Natural England review of G2.10 MRSea Baseline Sensitivity Report (Gannet) - Revision: 02
[REP3-029]

The construction and operation of Hornsea Project Four Offshore Wind Farm, located approximately 69 km from the East Riding of Yorkshire in the Southern North Sea, covering an area of approximately 468 km².

Planning Inspectorate Reference EN010098

10th May 2022

Monthly Spatial Density
 Distribution of Gannet Within
 Hornsea Four Plus 4 km Buffer
 Document no: HOW04_MRSea_5
 Created by: MB
 Checked by: SS
 Approved by: SS

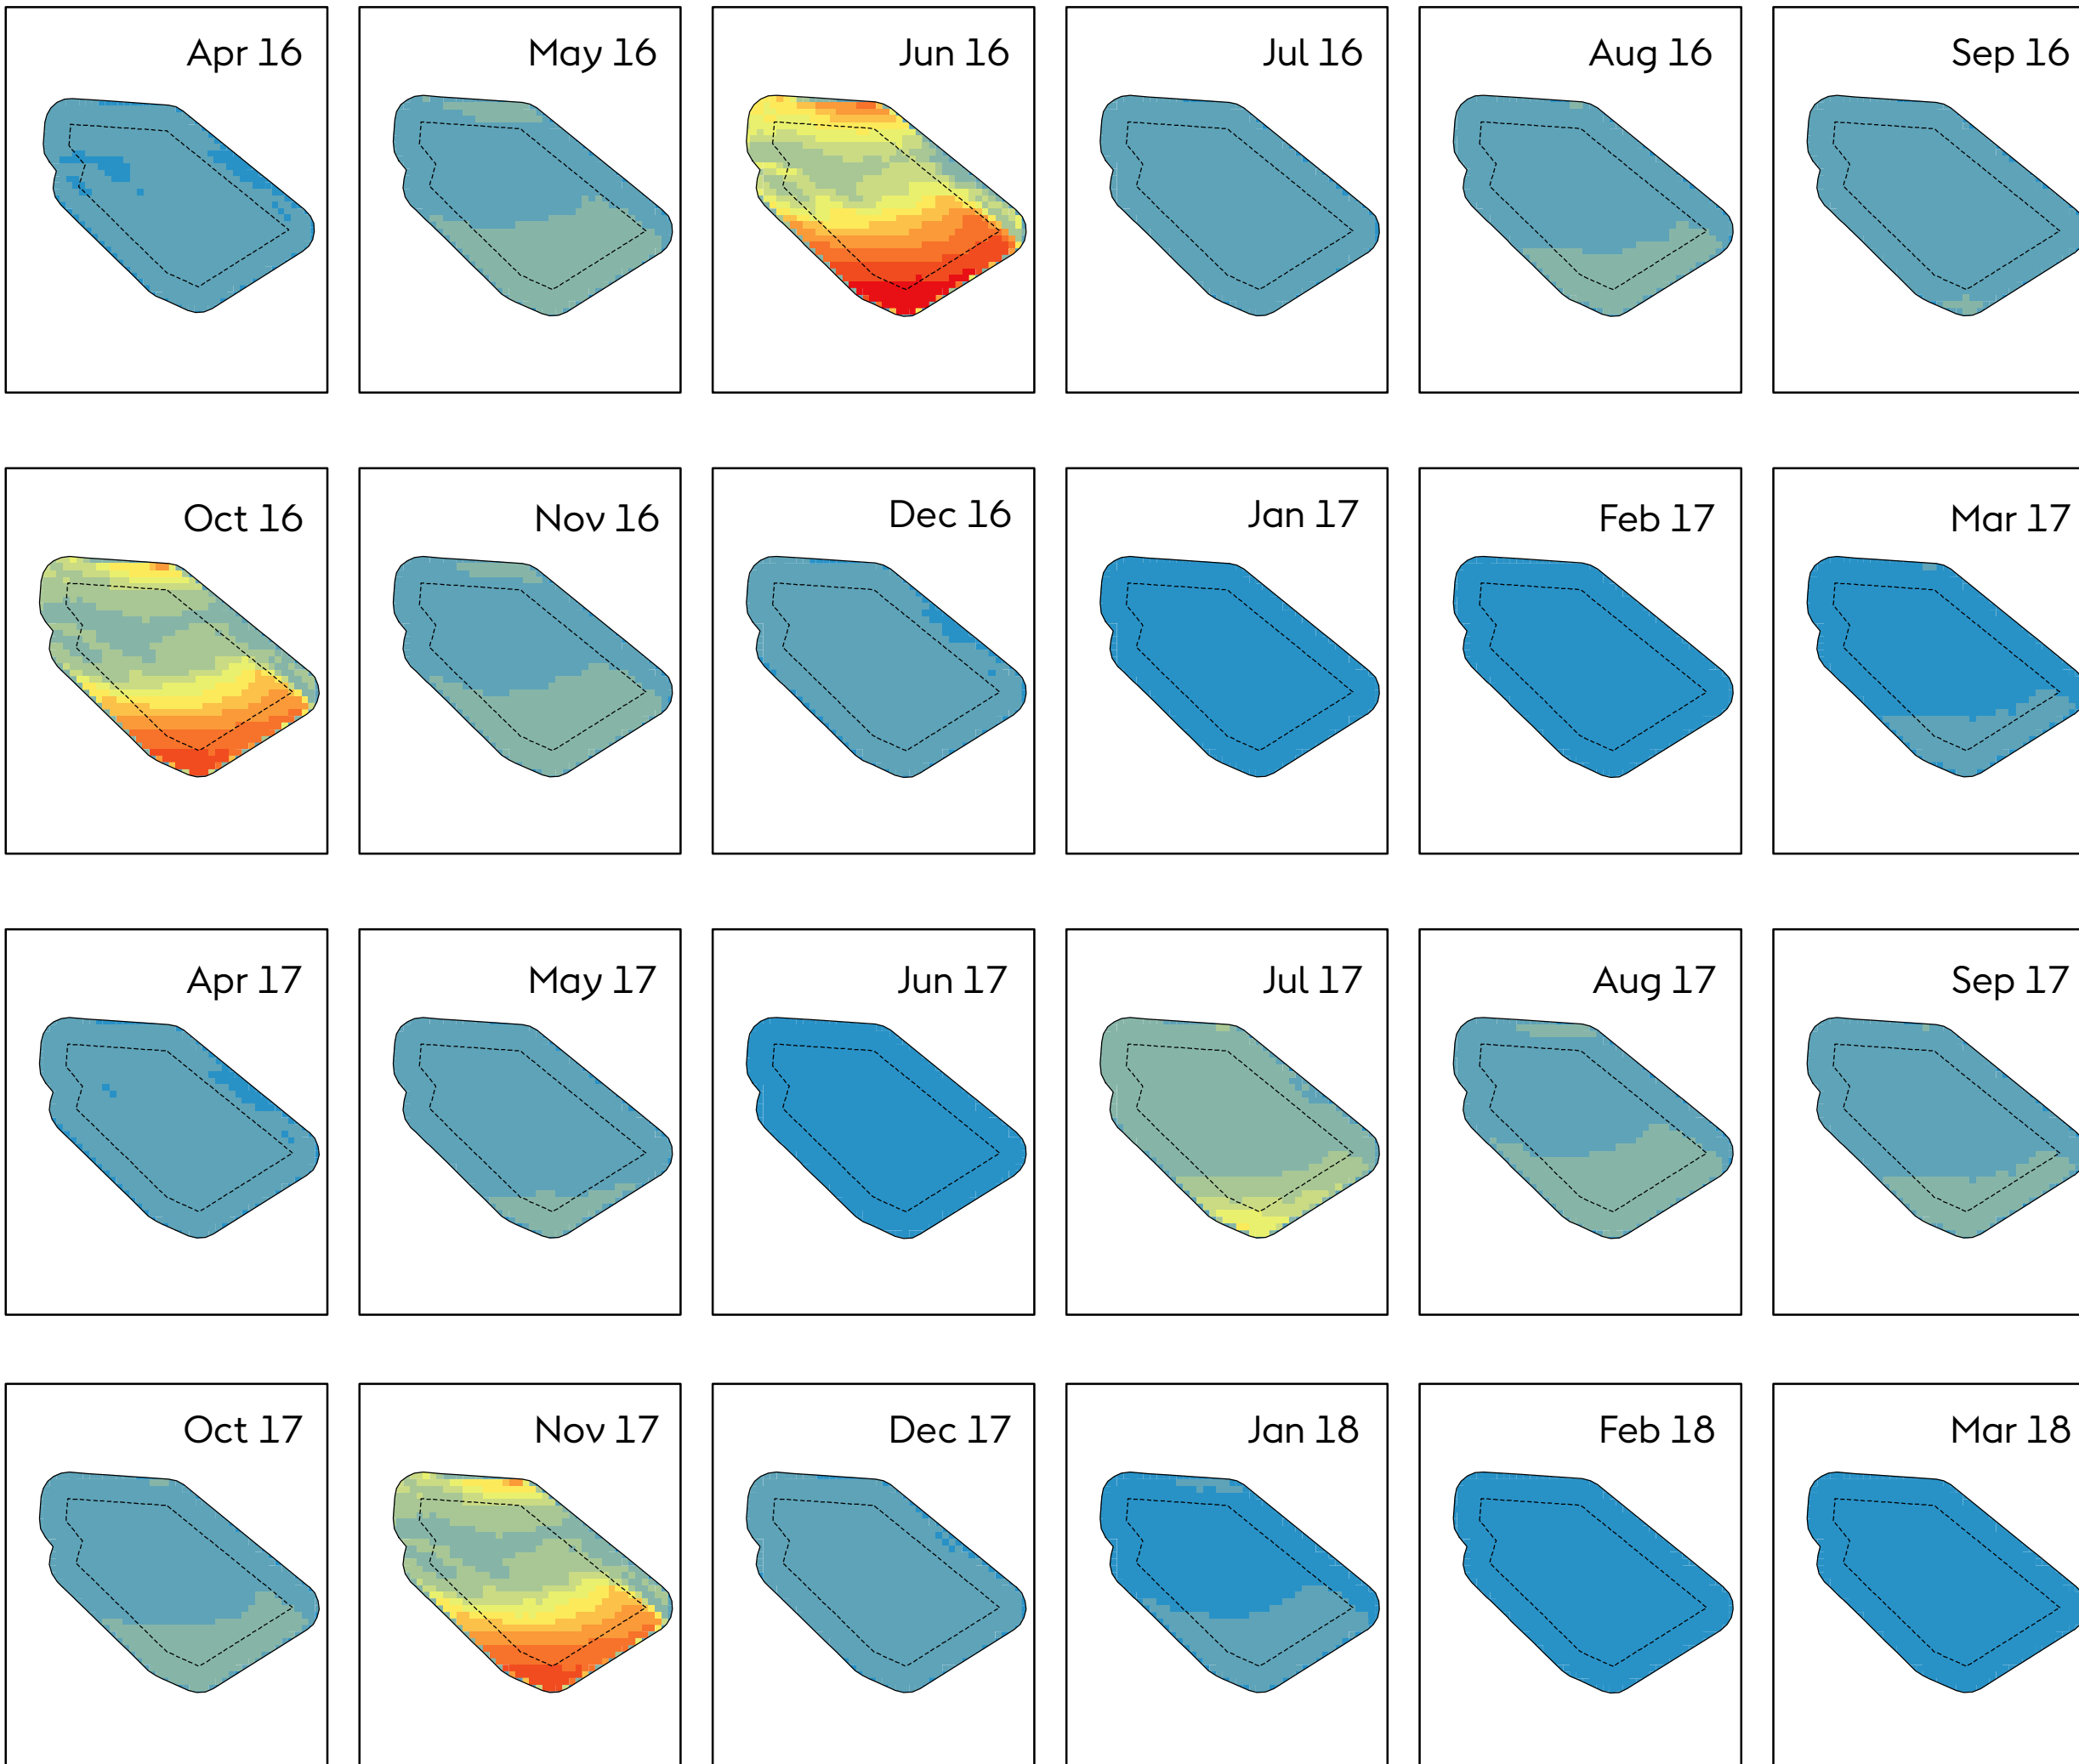
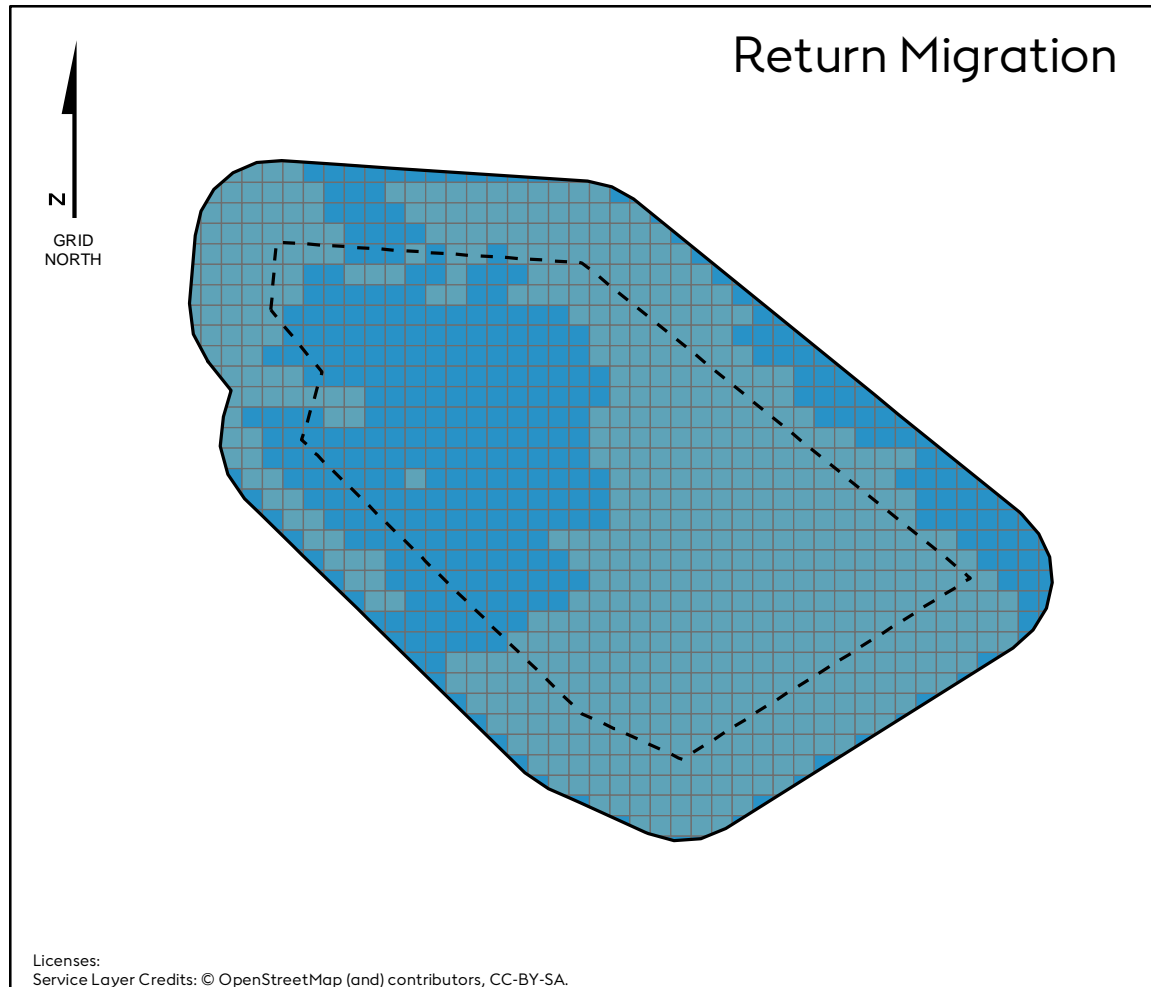
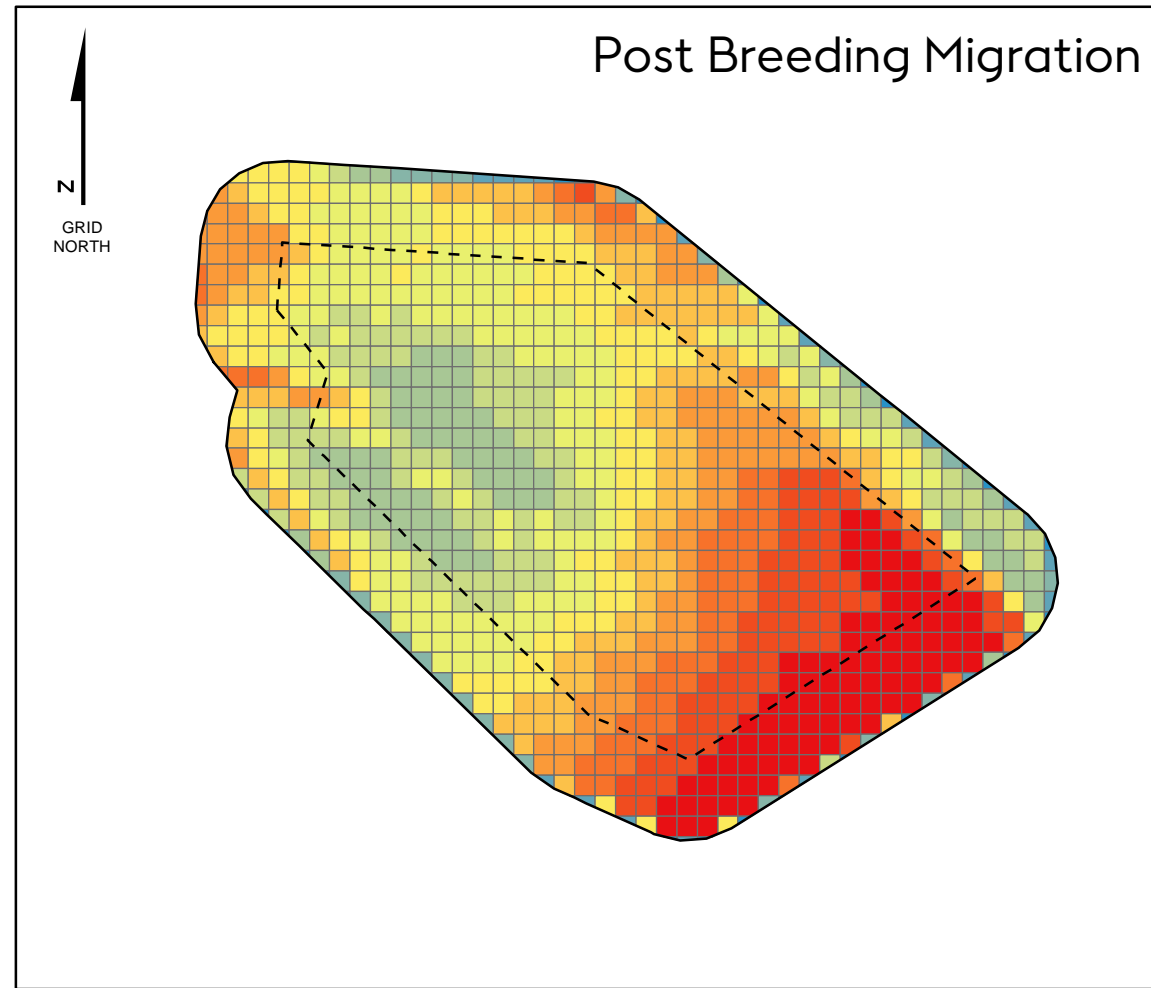
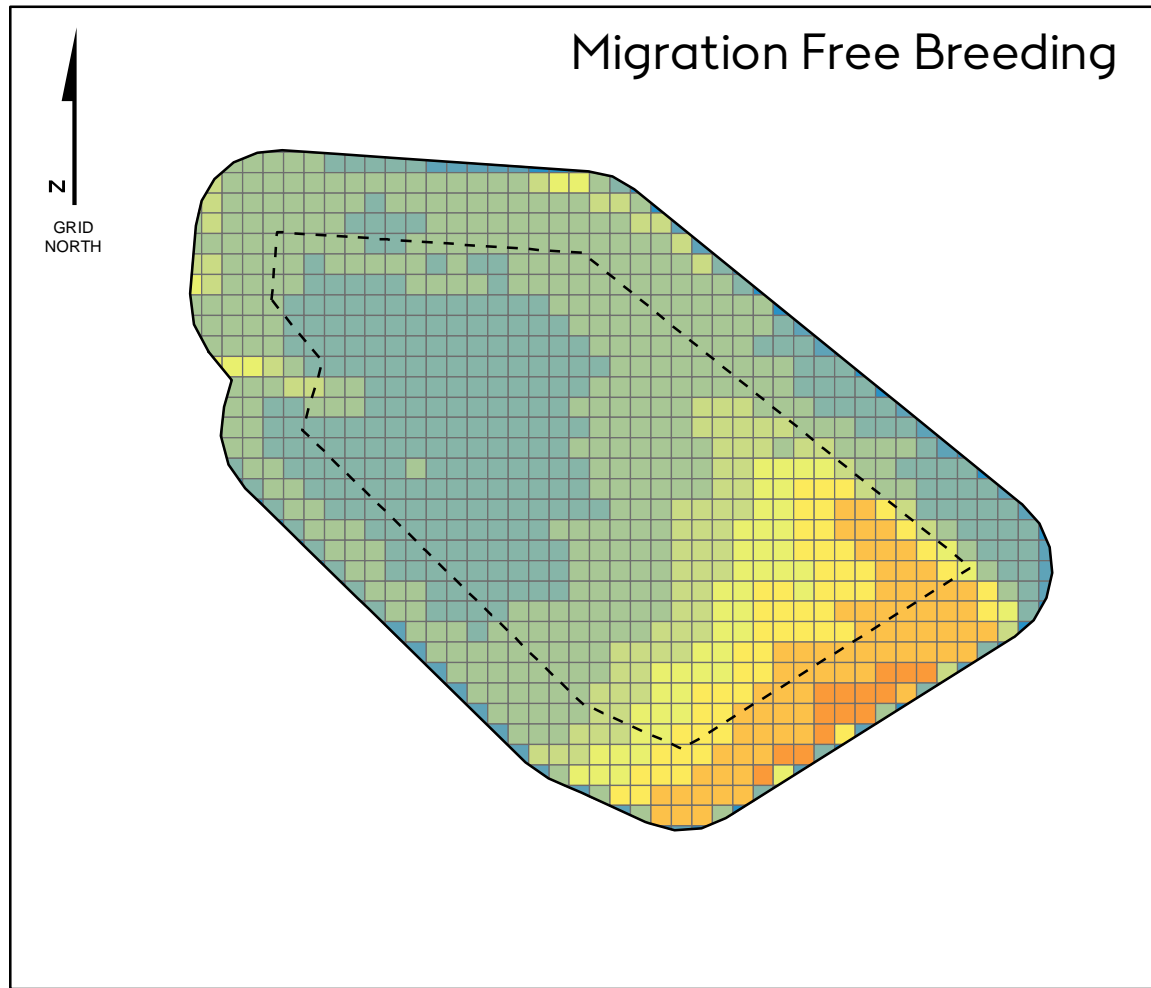
Natural England consider the results and information presented in this report fully justifies the concerns set out in our Relevant Representations [RR-029], and our recommendation to revise the modelling that underpins key elements of the ornithological impact assessment for EIA and HRA. In contrast to the original model, the revised model appears statistically sound and provides a superior fit to the raw data, with the spatial distribution of birds now more closely aligned with observed patterns, rather than having a fixed distribution across the entire survey period. This has resulted in notable changes to the predicted distributions and abundance estimates for gannet in some months.

Natural England welcome that the Applicant has consulted with CREEM during the revised modelling, providing greater confidence in the application of the MRSea tool and outputs. In particular, the presentation of the spatial distribution data clearly identifies the shortcomings of the previous modelling approach that did not include a spatial-temporal interaction. The fitted surfaces now much more closely match the underlying raw observations (see Figure 1 below for an example).

Critically, the model framework now includes “month” (12 months) or “bio-season” (3 periods), rather than survey (24 surveys), as the temporal explanatory variables in the model. This reflects a significant change from the previous modelling (MRSea_v1) that underpinned the assessment in the DCO Application. This newly adopted approach effectively pools surveys in the same months, or bio-seasons, under the assumption that there is no significant variation between months in different survey years. The selected model, including “month” as the temporal term, therefore produces a single prediction for each calendar month, rather than for each individual survey as in the former modelling. Unfortunately, this has resulted in a fundamental mismatch between the model outputs and data requirements for the displacement assessment as set out in SNCB guidance. The displacement assessment requires the use of individual survey estimates, rather than combined monthly ones, to capture interannual variability in the timing and magnitude of peaks in the abundance of species within discrete seasons.

The use of combined monthly estimates could result in a significant underestimation of impacts if the timing of peaks varies between years, and it would also be inconsistent with SNCB guidance and the approach taken for all other offshore wind farm assessments to date. To demonstrate the potential implications of this on the number of gannet subject to displacement impacts, we can use the design-based estimates provided in the report to illustrate the

2. For gannet, revise the modelling to include 'survey' or 'year/month' as the only possible temporal variables. This would provide individual survey estimates that can be used in both displacement and collision risk assessments. Alternatively, if this is not possible in time to provide updated assessments at Deadline 5, we would recommend the use of the MRSea_v2 estimates for the collision risk assessment and design-based estimates for displacement.

2. Depending on time constraints, revise the modelling for gannet. If this is not possible in time to provide updated assessments at Deadline 5, use the MRSea_v2 outputs for collision risk assessment and design-based estimates for the assessment of displacement.

We suggest that if it is possible to provide a revised model that results in individual survey estimates, this should be used to inform both displacement and collision risk assessments for gannet. This could be achieved by constraining the temporal explanatory variables to either 'survey' or 'year/month' combination and ensuring that any other model parameters are adjusted accordingly (e.g. blocking structure). The Applicant has stated that they have already trialled such a model for gannet (Hornsea 4 pers. comm., 20th April 2022) which we hope will reduce the time needed to address this.
